Application Ref:	3/2026/0567			 Ribble Valley Borough Council www.ribblevalley.gov.uk
Date Inspected:	22/01/2026 (as part of pre-application enquiry)	Site Notice:	N/A	
Officer:	MC			
DELEGATED ITEM FILE REPORT:				APPROVAL

Development Description:	Conversion of redundant barn to form extension to existing dwelling and granny annexe. Insertion of solar panels to front elevation of dwelling.
Site Address/Location:	Cowley Brook Farm, Higher Road, Longridge, PR3 2YX

PROPOSED ELEVATIONS
(SHEET 2 OF 2)

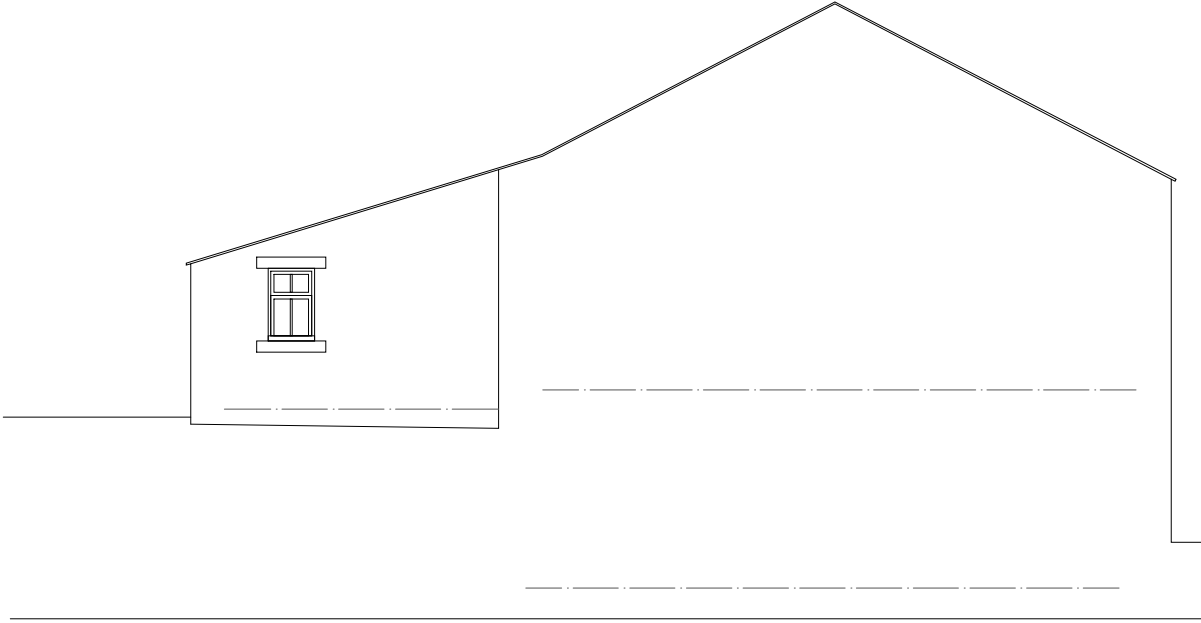
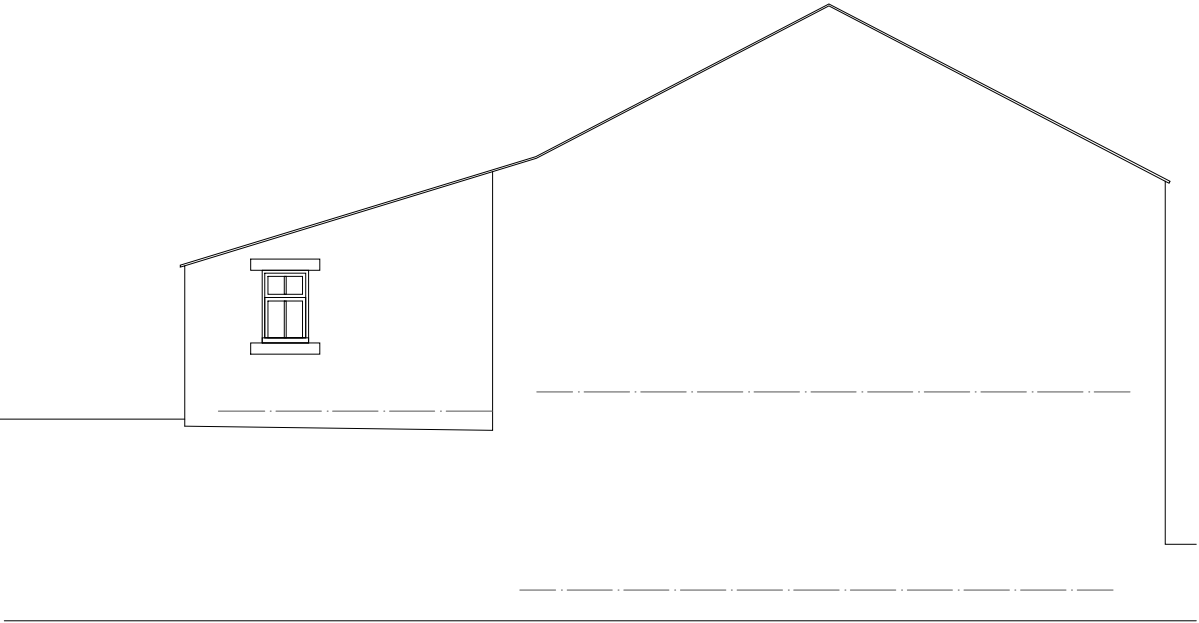
To the rear elevation, the proposal re-locates two existing rooflights to the rear roof of the main dwelling which is considered to be acceptable. Two new conservation type rooflights would be introduced to the rear roof of the barn. The introduction of these rooflights is considered acceptable and would not dominate the roof slope. Their positioning within the roof would also not appear overly uniform with one rooflight being set lower towards the eaves.

Turning to new openings to the rear wall, the proposal would utilise the existing rear openings to facilitate an office. Three stable doors would be inserted to include two windows with timber boarding below and one timber stable door. Given that these would utilise existing openings, this is acceptable and the introduction of stable doors would be similar to that already approved under planning ref: 3/2016/0959. The retention of the middle opening as a fully timber door would help reduce uniformity.

The proposal would also introduce new patio doors, a ground floor window and a new first floor window. Whilst these new openings would result in a more domestic appearance to the rear of the barn, the principle of introducing these new openings has already been established under the granting of planning permission ref: 3/2016/0959.

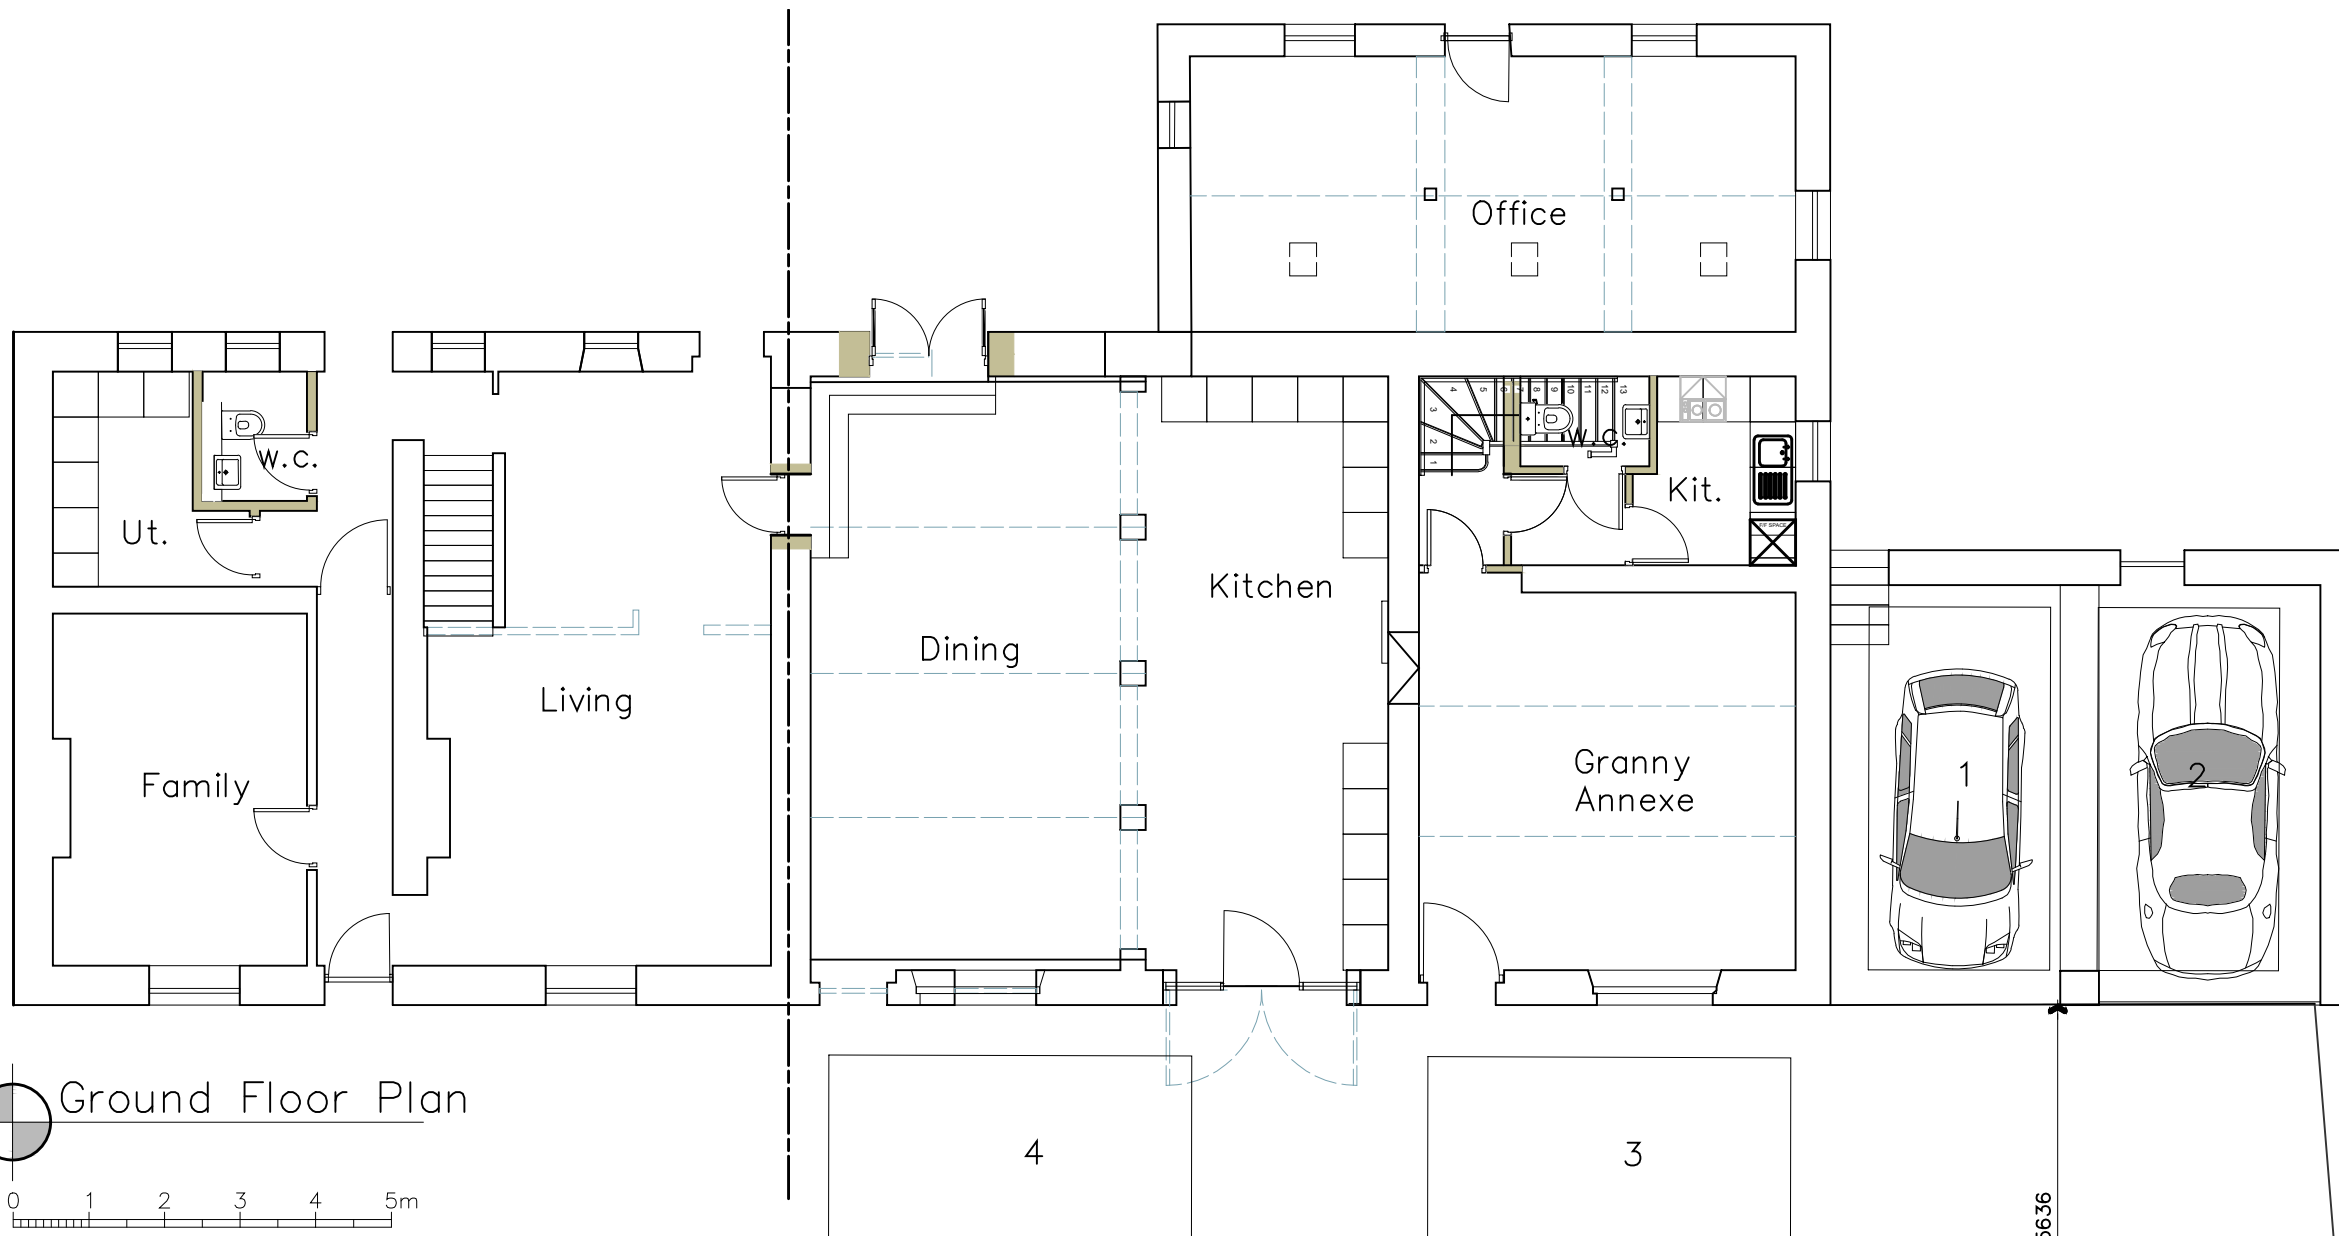
The floorplans indicate that the granny annexe would have a separate access from the front, a ground floor room with small kitchen and downstairs w/c and a first-floor bedroom with en-suite. Whilst the proposal would not be connected internally to the main dwelling, the proposal provides a modest level of accommodation which can be secured by way of planning condition as ancillary to the main dwellinghouse.
